Recommendation Report for Planning Permission for Works or Extension to a Dwelling

REF NO: P/13/20/HH

LOCATION: Sefter Cottage
Pagham Road
Pagham
PO21 3PX

PROPOSAL: New detached garage.

**Block Plan**

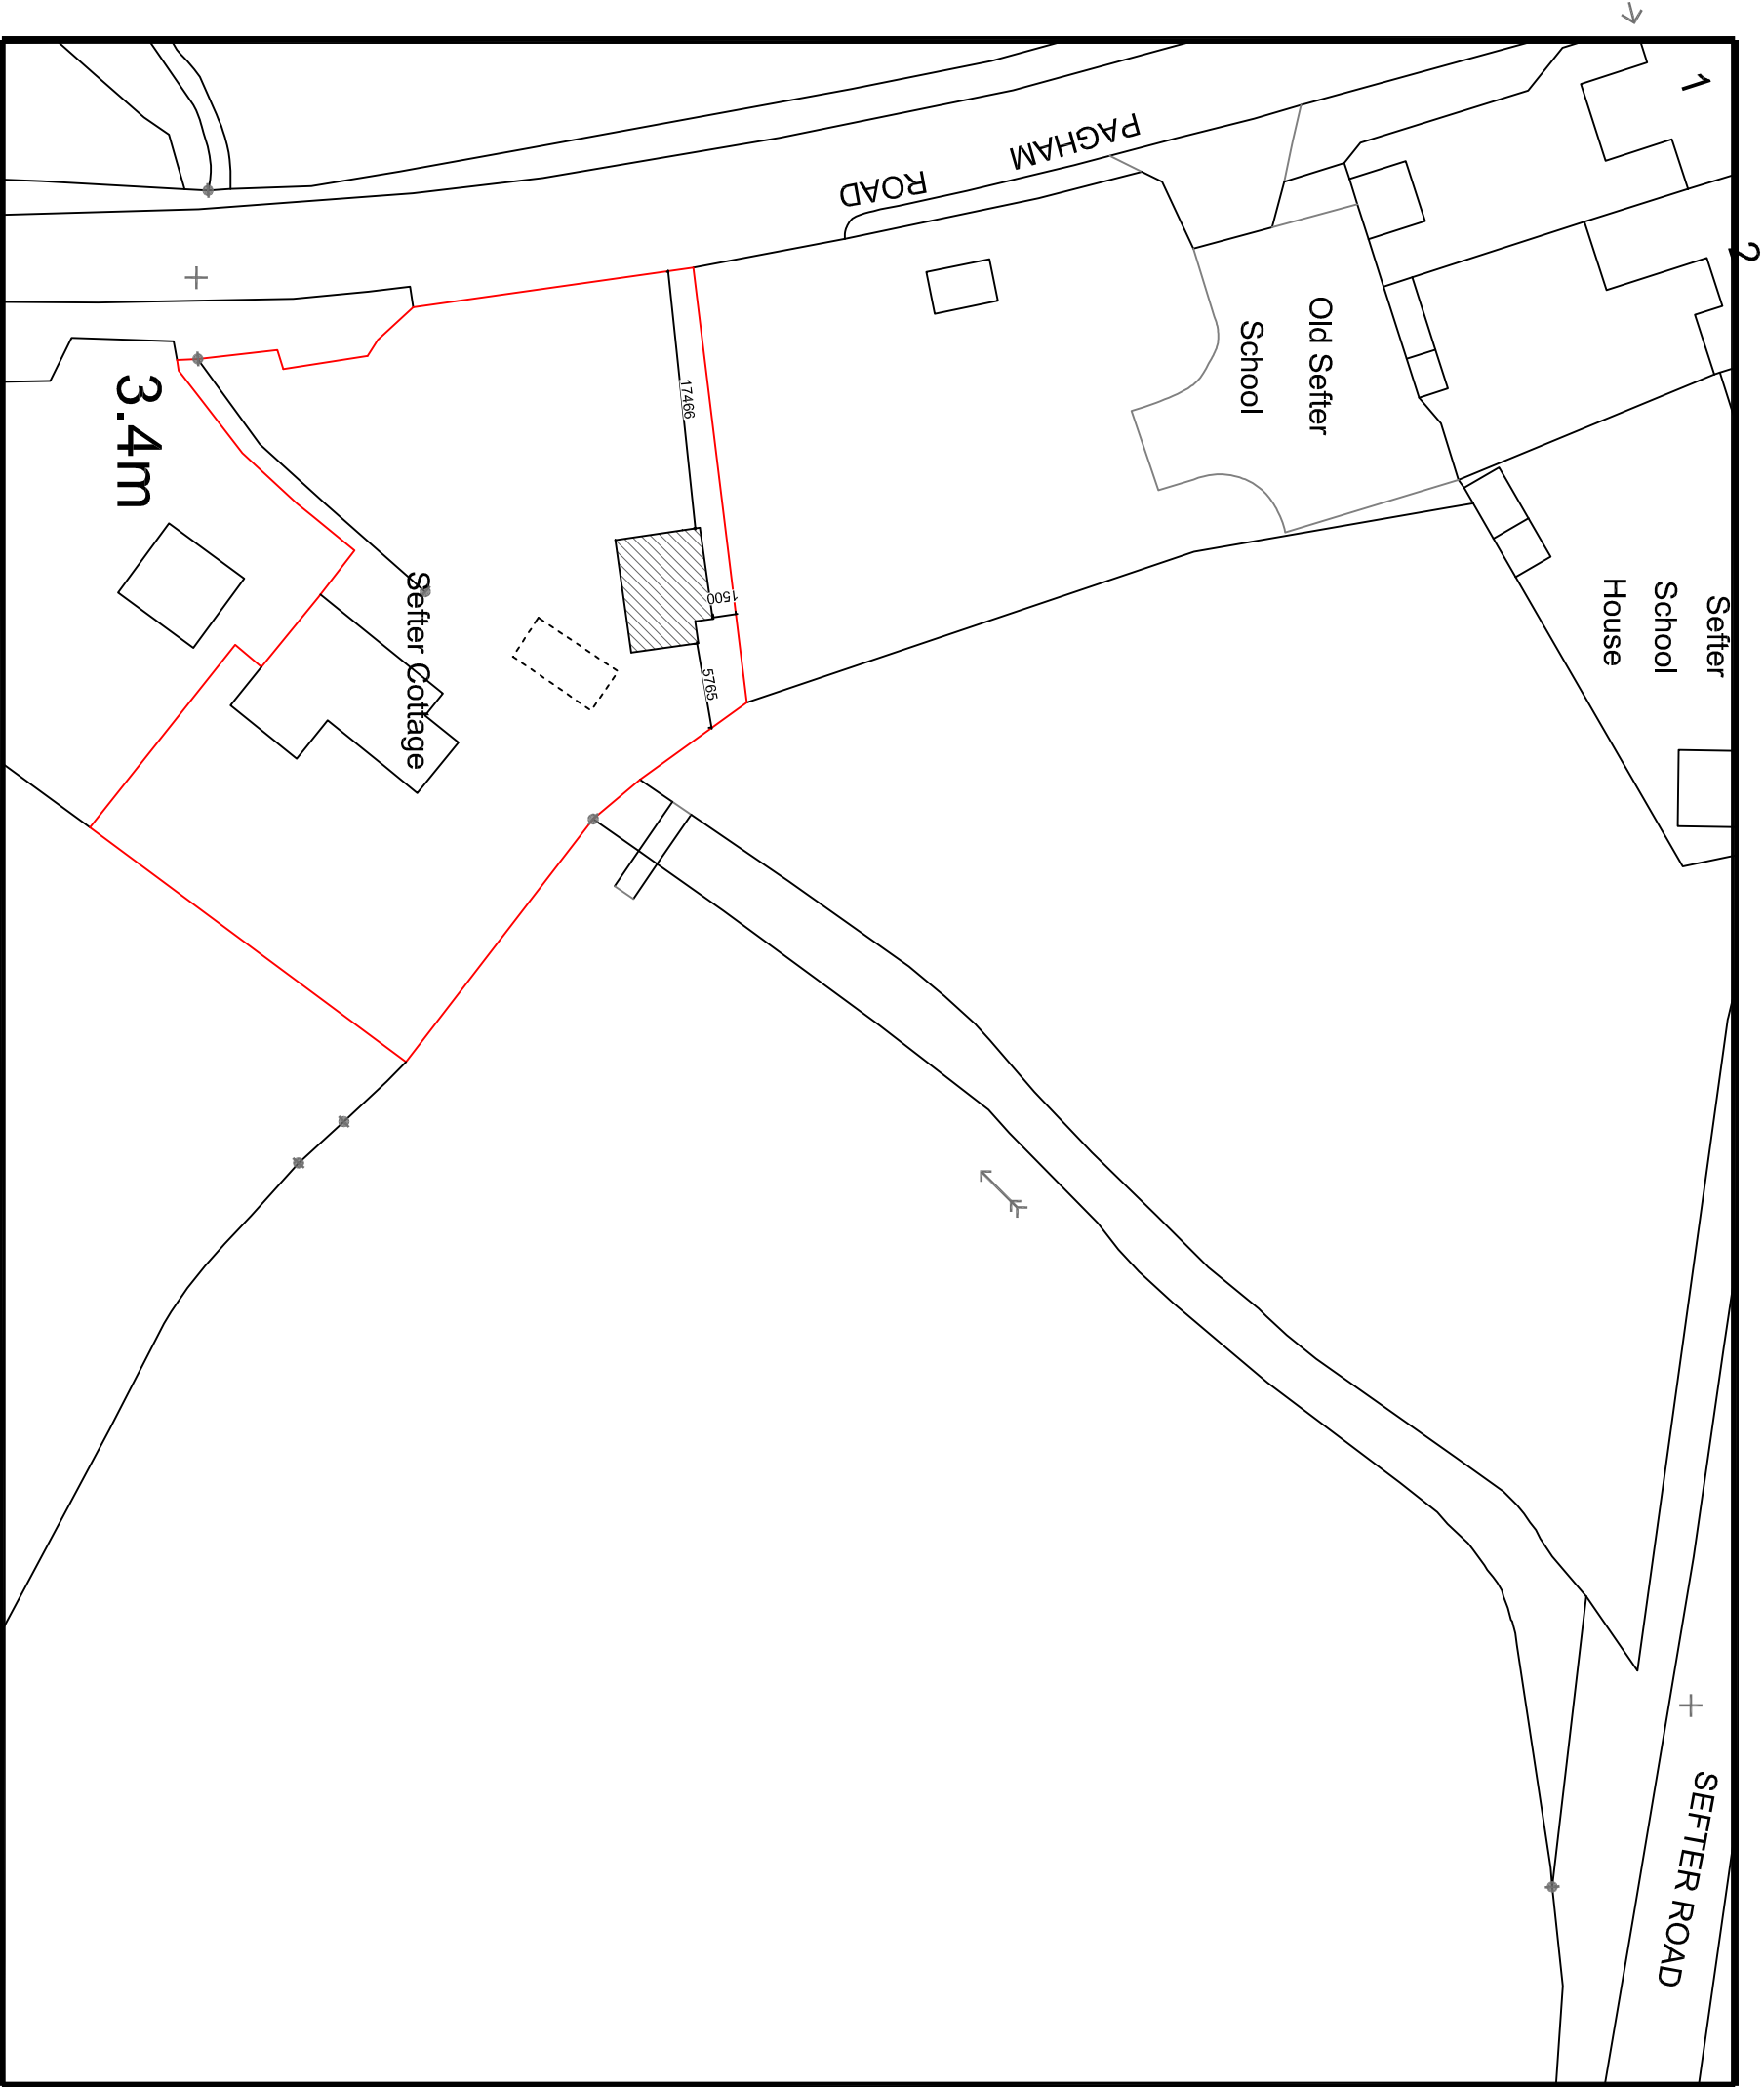
No objection but would note a ditch crosses the road and measure should be taken to ensure drainage is preserved.

The proposed development falls outside of the built up area boundary. However the application seeks permission for development within the curtilage of an existing dwelling. Therefore the principle of development is considered acceptable and as such will be assessed against relevant development plan policies. The concerns of the Parish are noted however the proposal does not include details of any works to the ditch so would not be approved by this application.

2.5 Bay Garage & Workshop
Planning Drawing

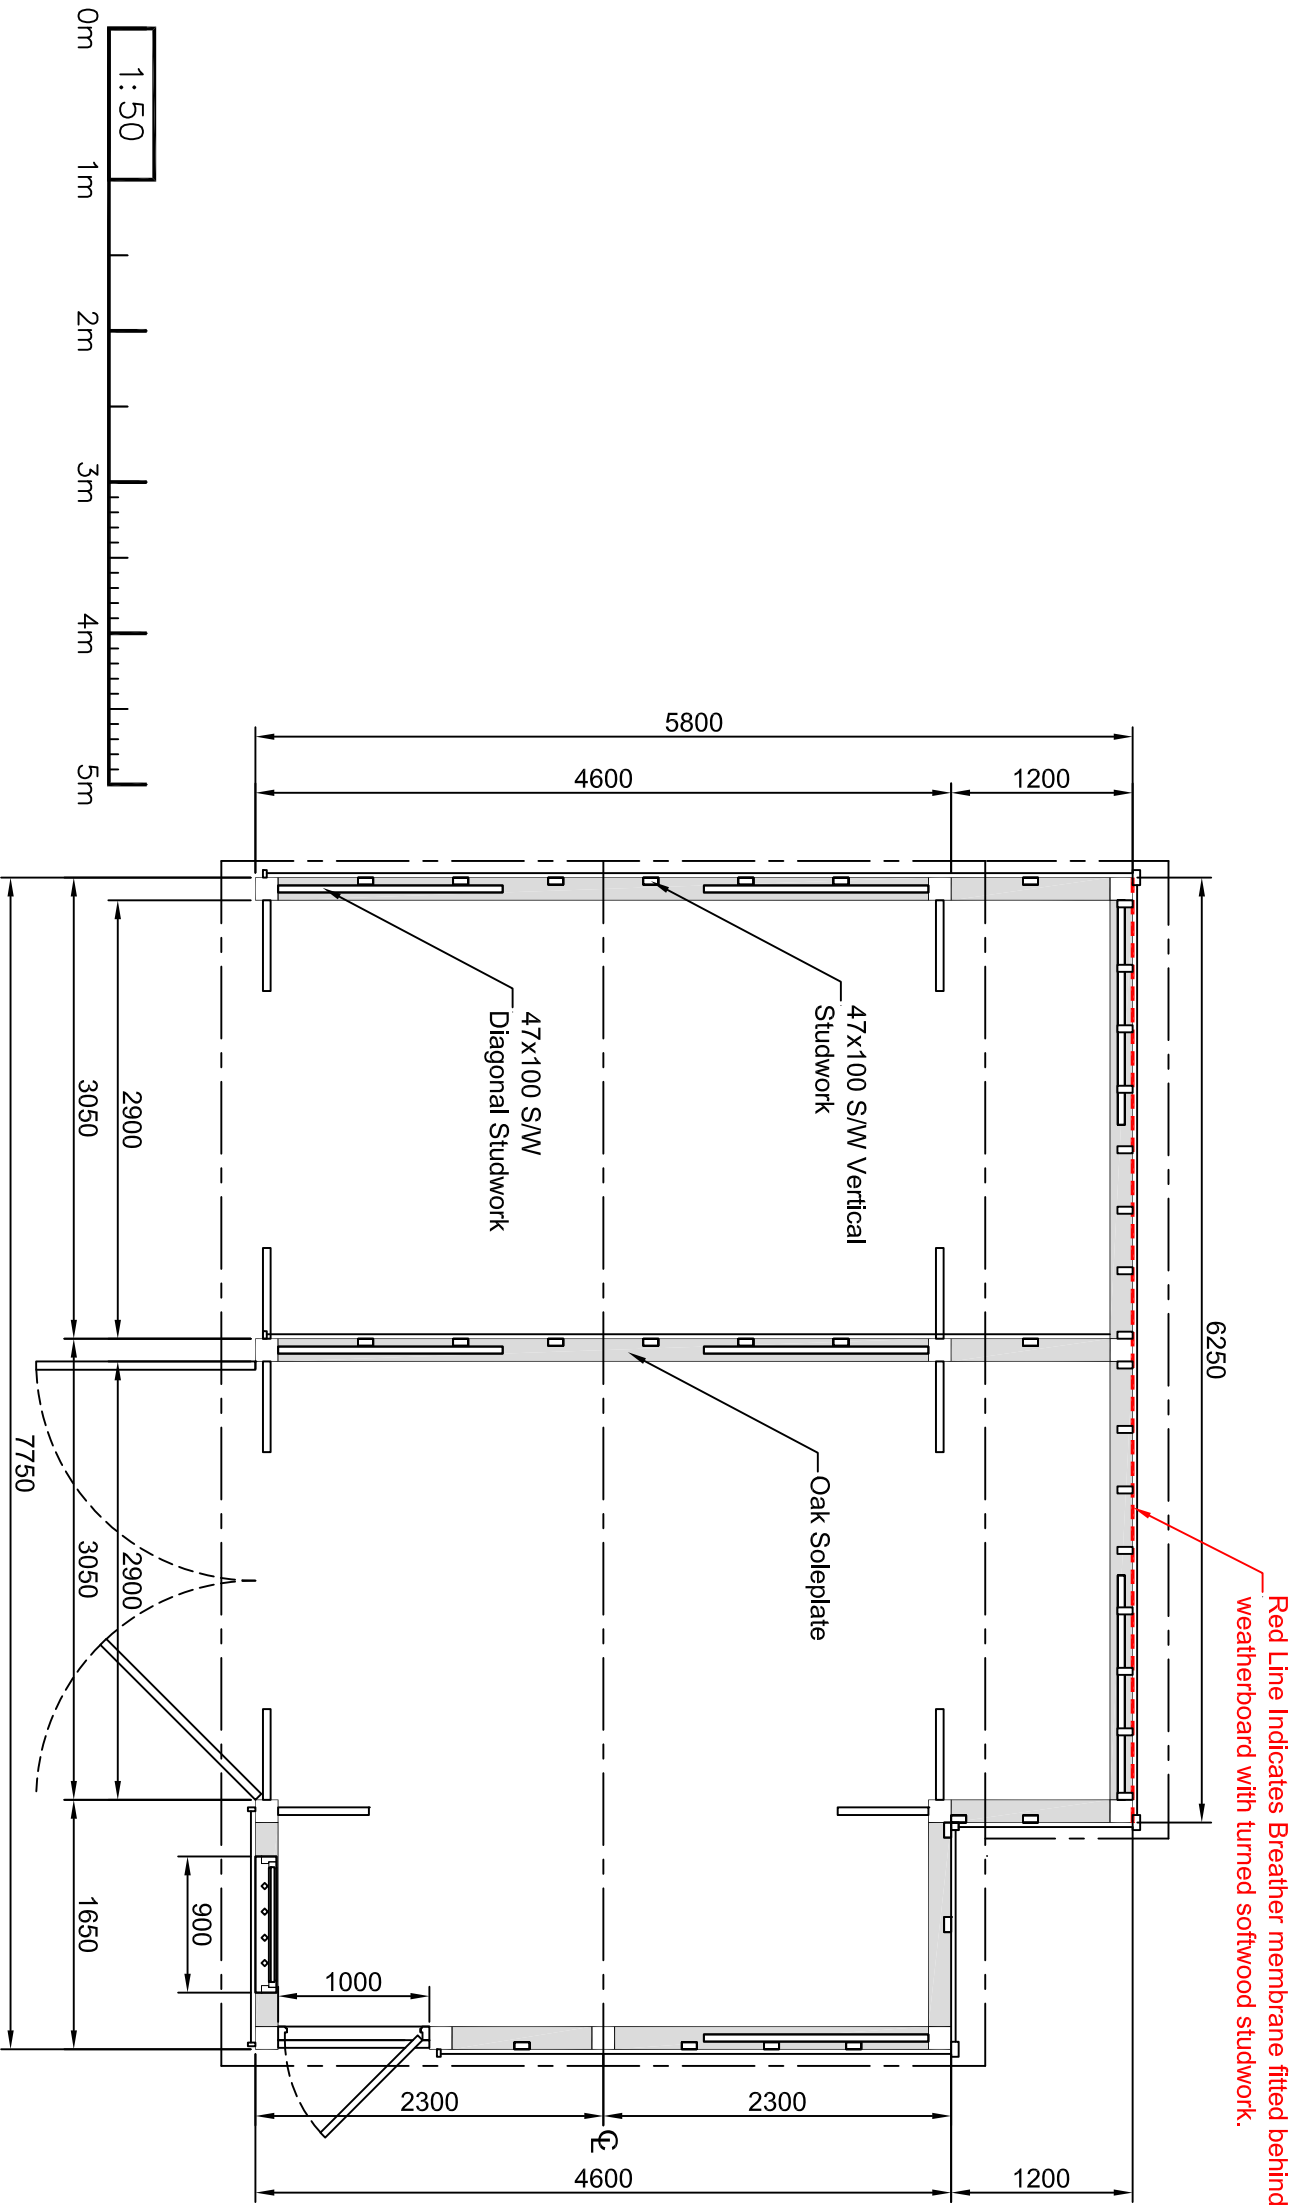
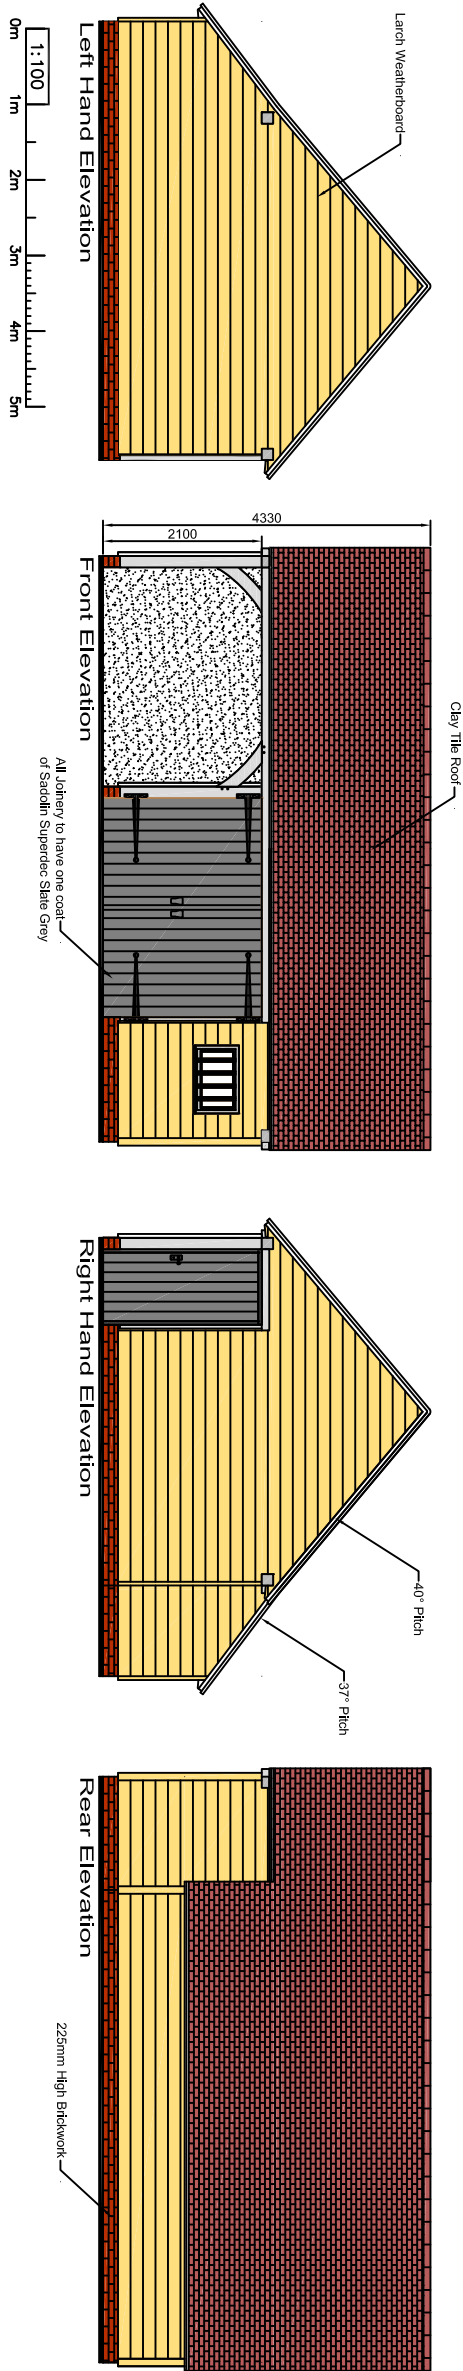
The proposal seeks to construct a detached garage. This will be situated 17m from the front boundary of the property and with sufficient planting along the boundary, views will be restricted. The garage will be constructed of larch weatherboard with a clay tile roof. These materials are considered appropriate to their setting. The structure is relatively large and will consist of an open fronted area sufficient for 1 car and then double doors with space for another vehicle.

The garage will have a width of 7.8m and a depth of 5.8m. It will have a height of 4.35m and will have a cat slide roof, reducing to 1.5m and 2.25m to the eaves. Due to the siting of the garage, with no neighbouring properties to the rear or side boundaries, the development is not considered to result in adverse impacts upon amenity. The garage doors are situated to the front and face the dwelling with one door facing the rear boundary.
